Memorandum

To: Carmen Moran, Director of Development Services
From: Gordon C. Robbins, Deputy Fire Chief
Date: Thursday, March 06, 2008
Re: Case 1554-Z/Best Publishing

OVERALL FLOOR PLAN A1
SCALE: 1/16" = 1'-0" A1.2

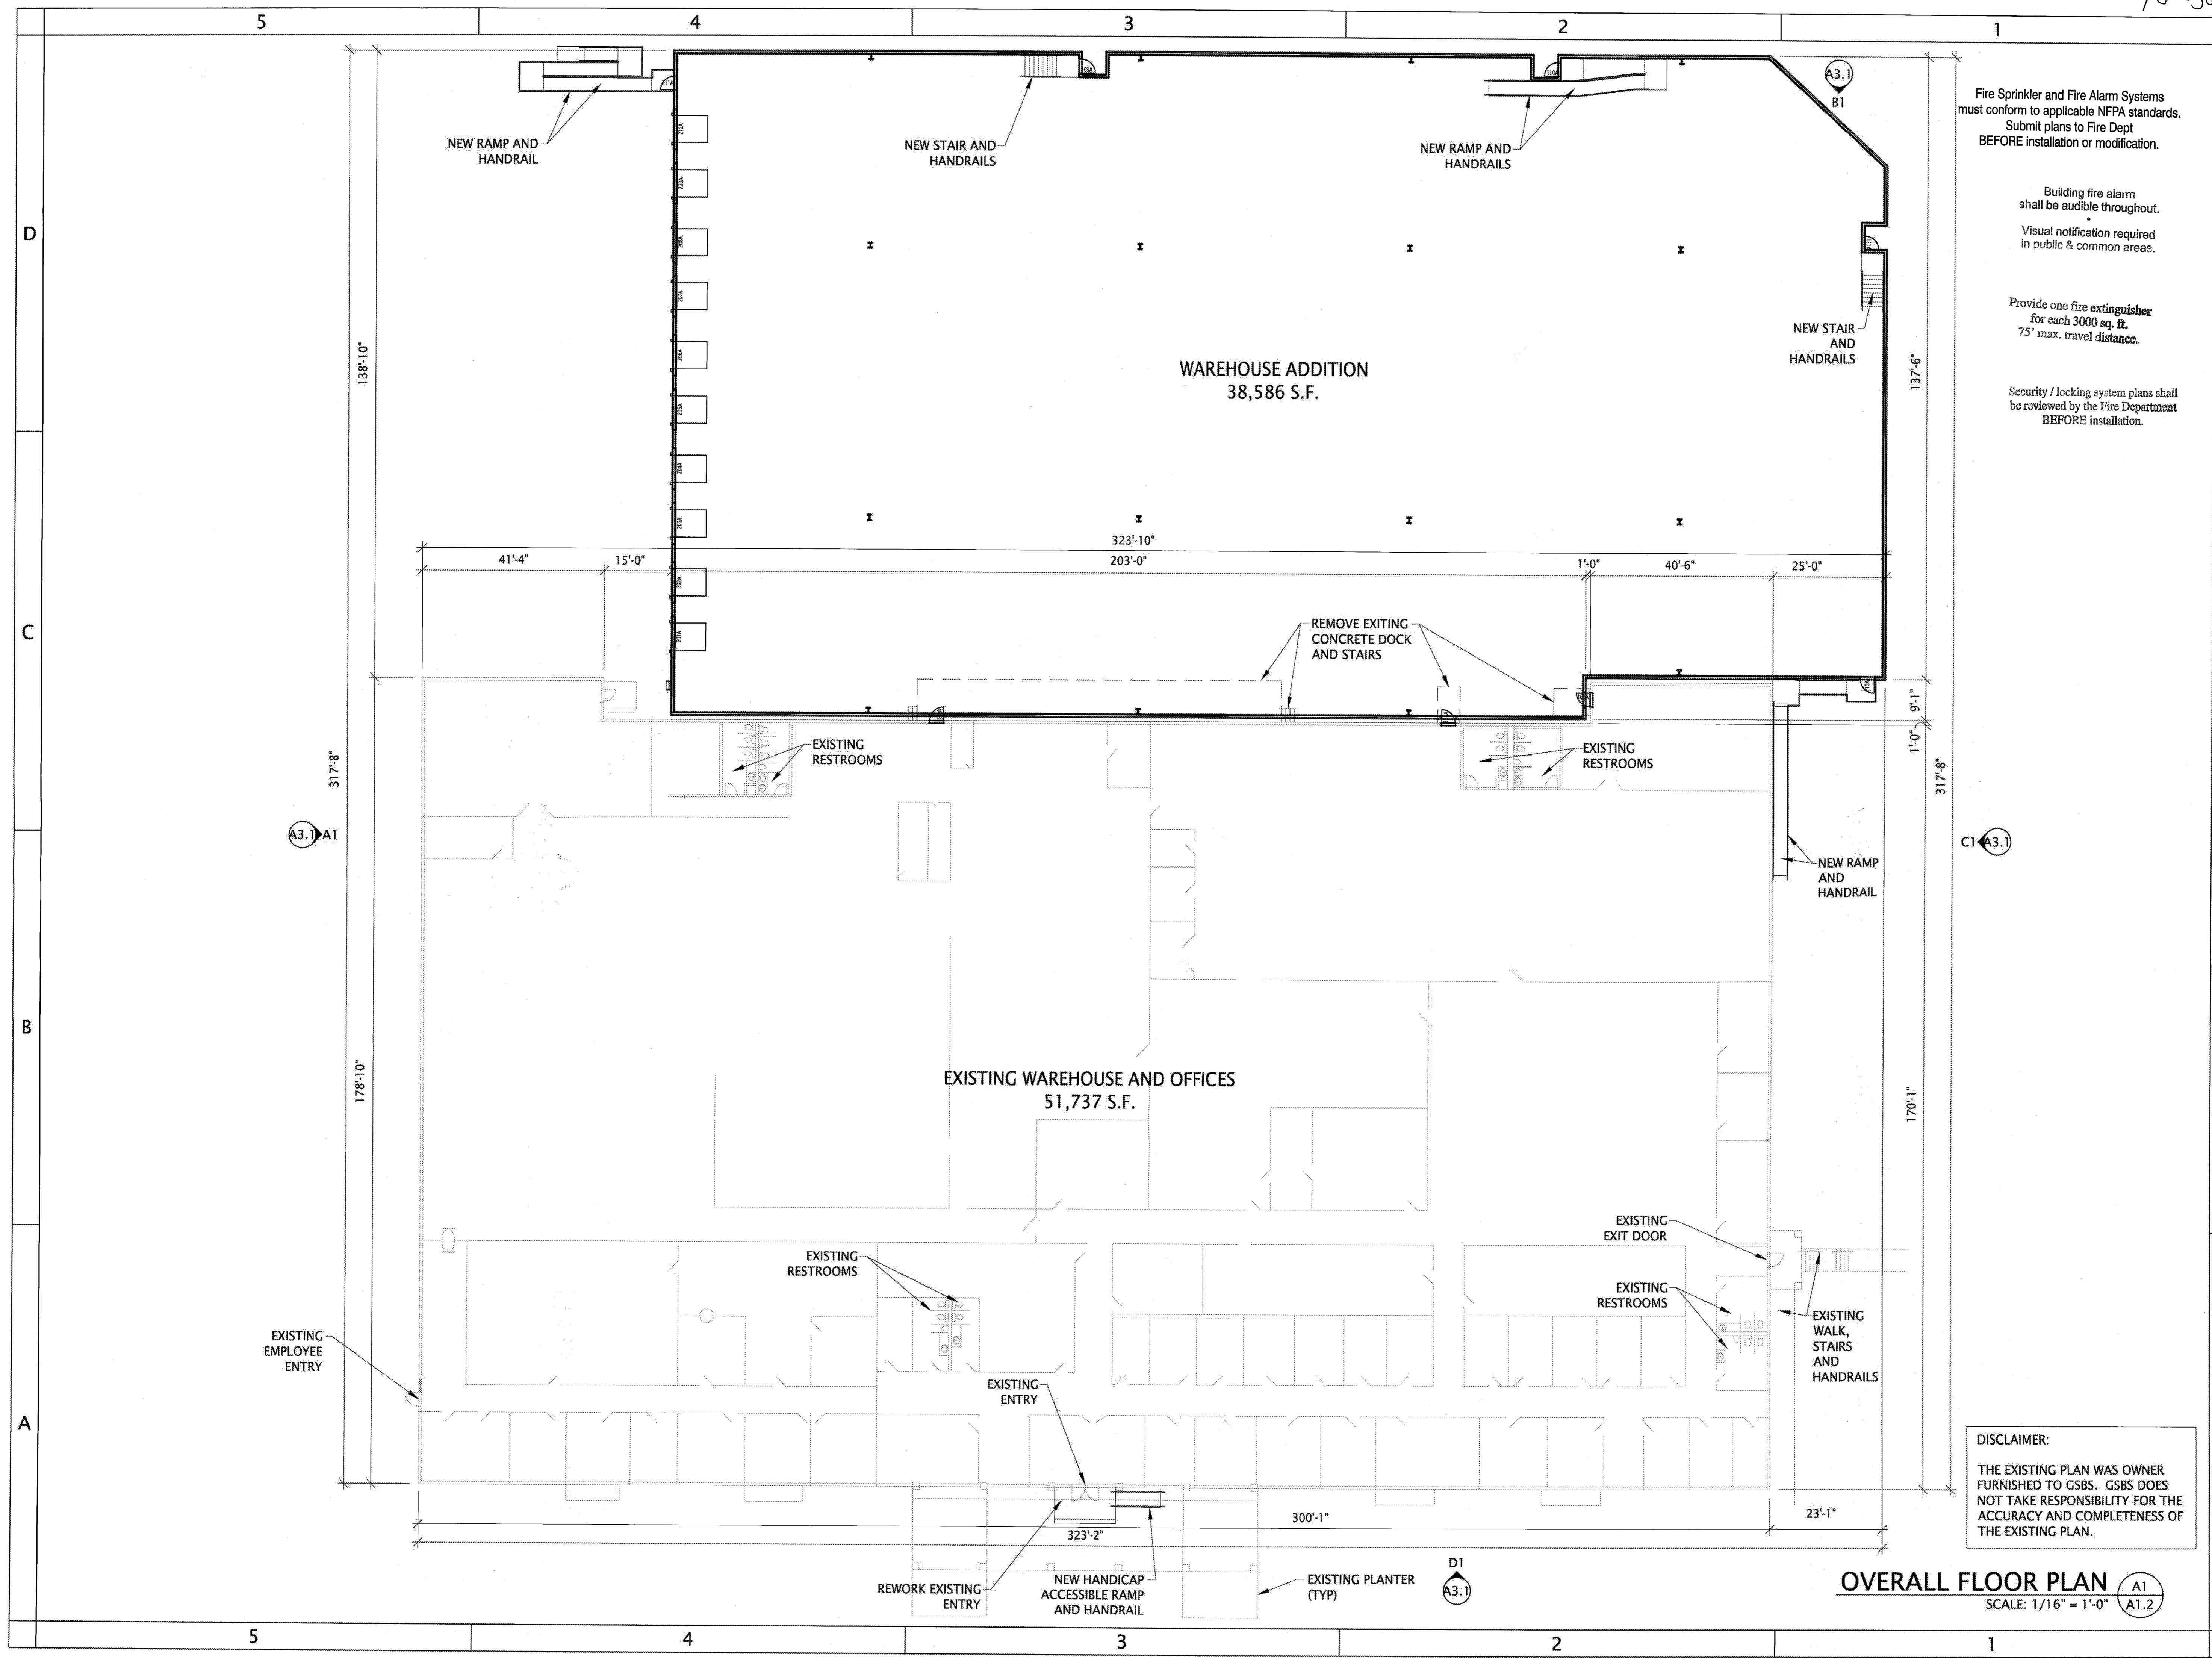
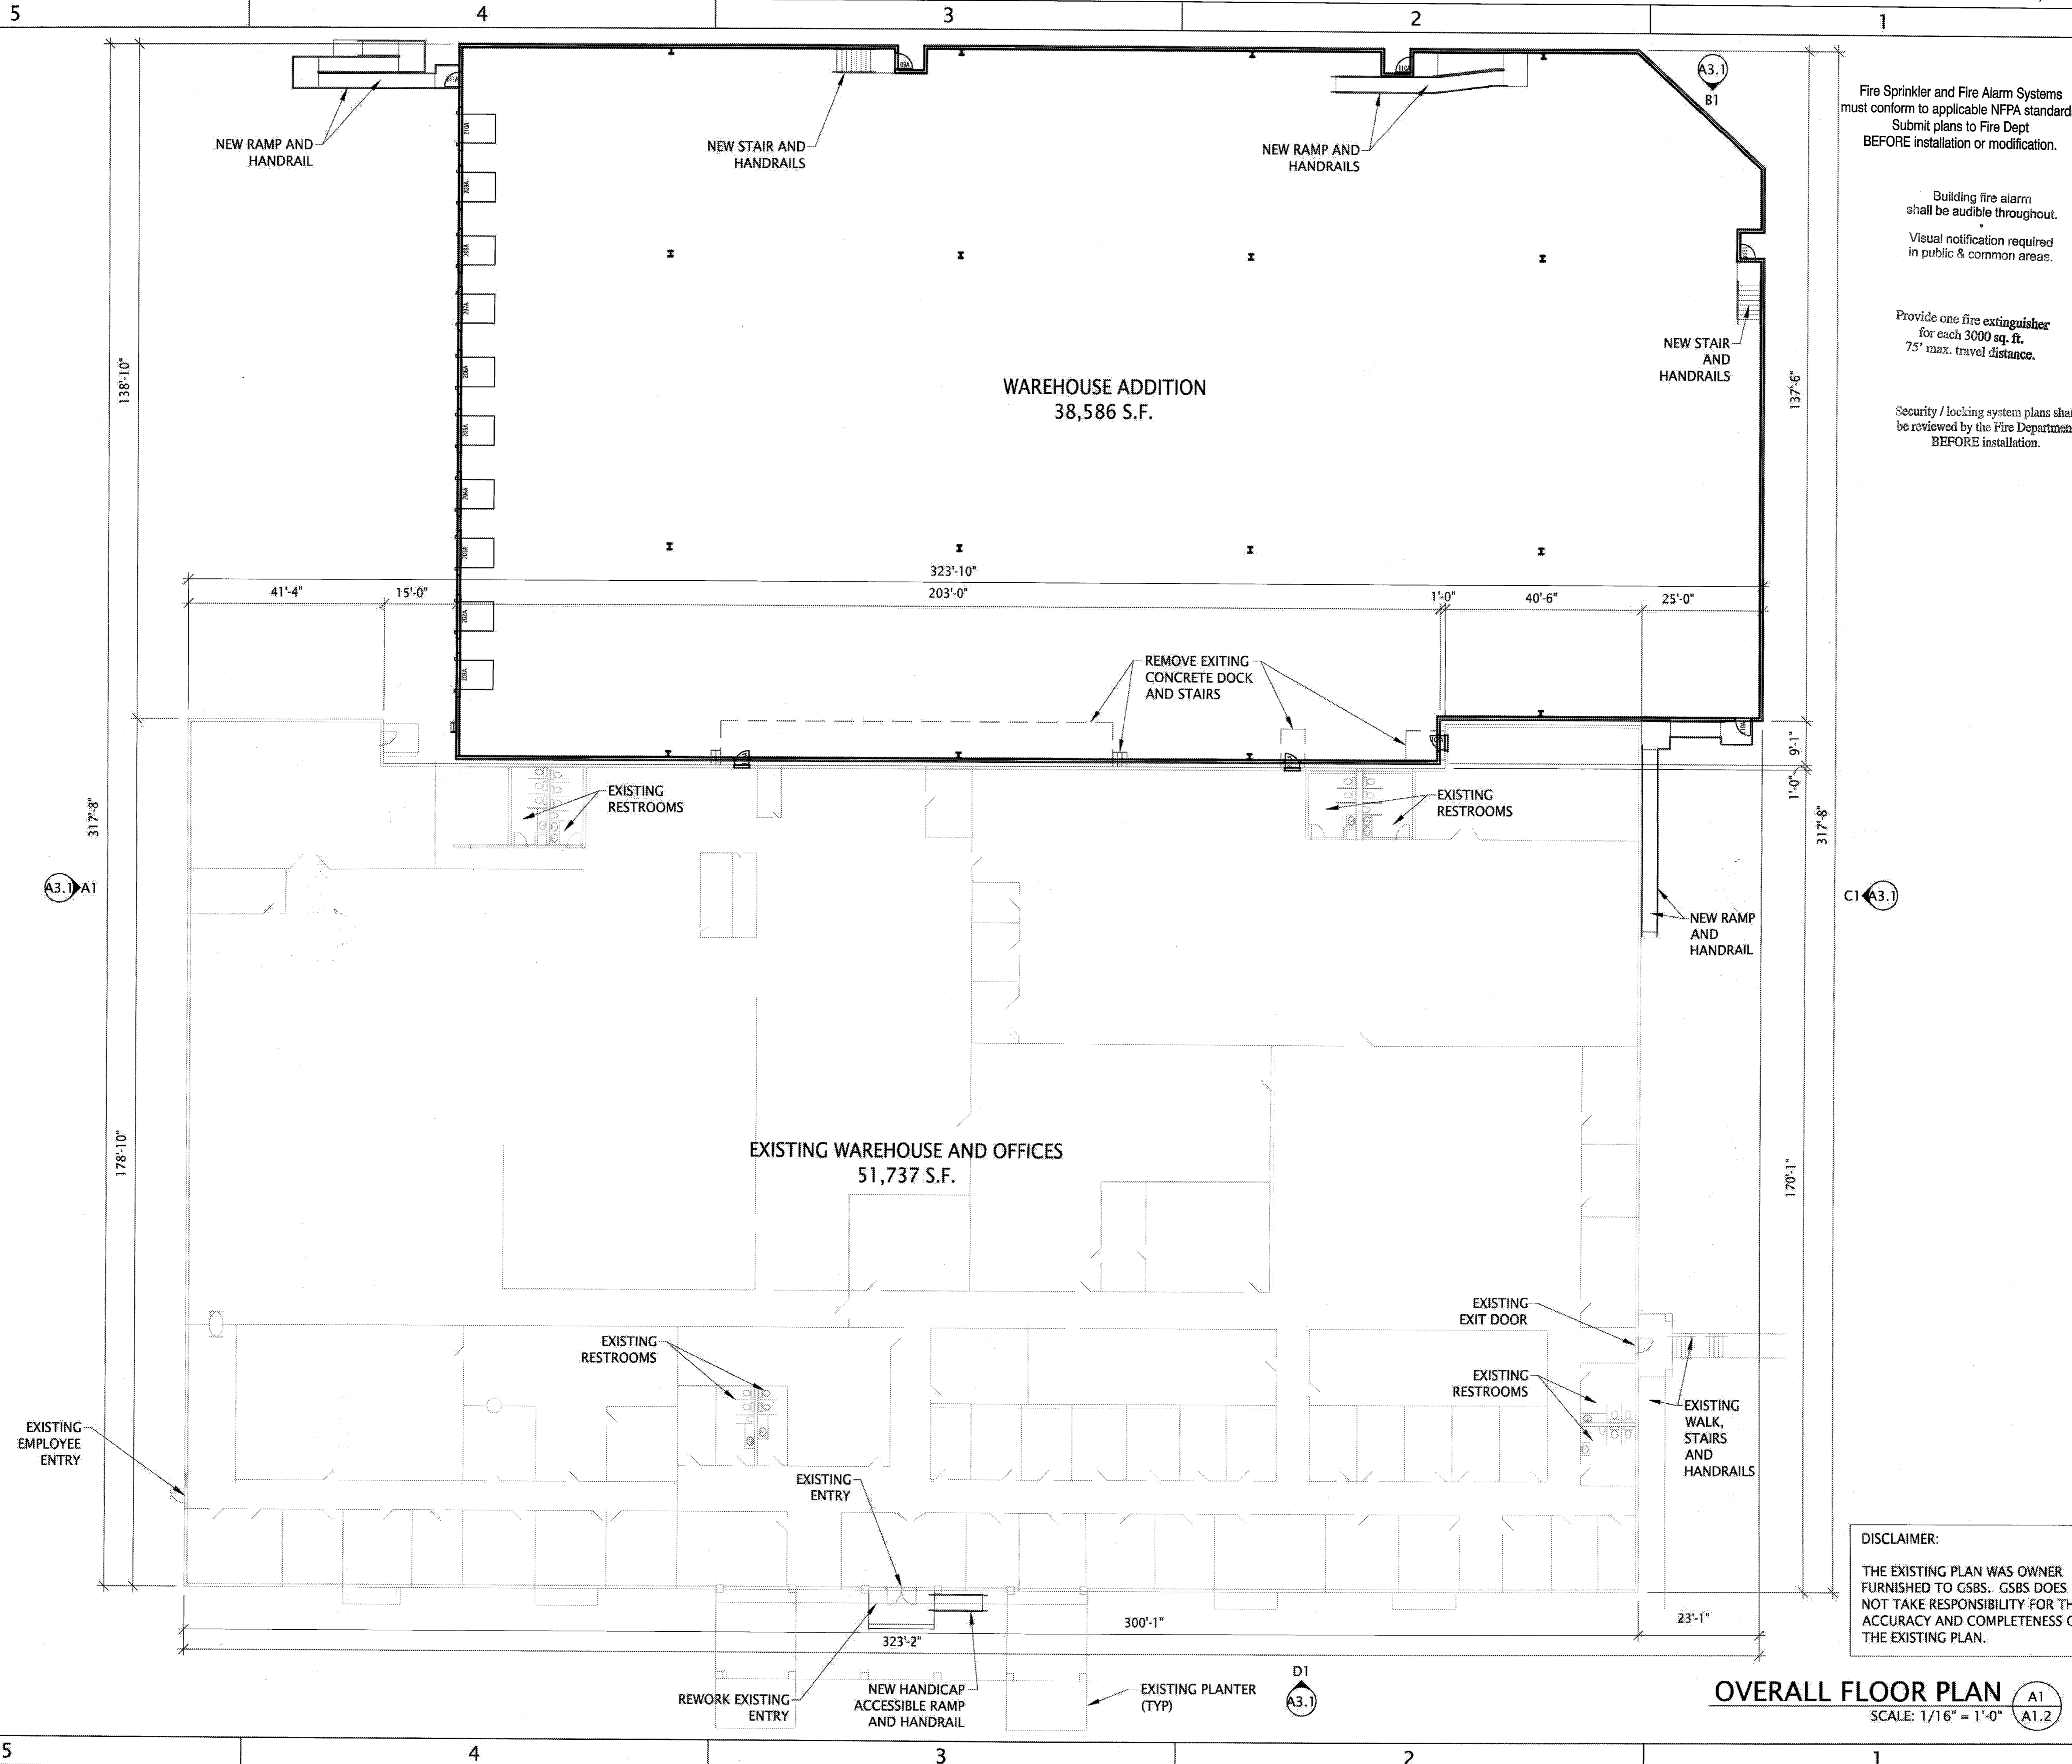
However it will be necessary to install fire sprinklers in the new structure. The existing portion of the structure must then be sprinklered also or properly separated the new by an approved firewall assembly.
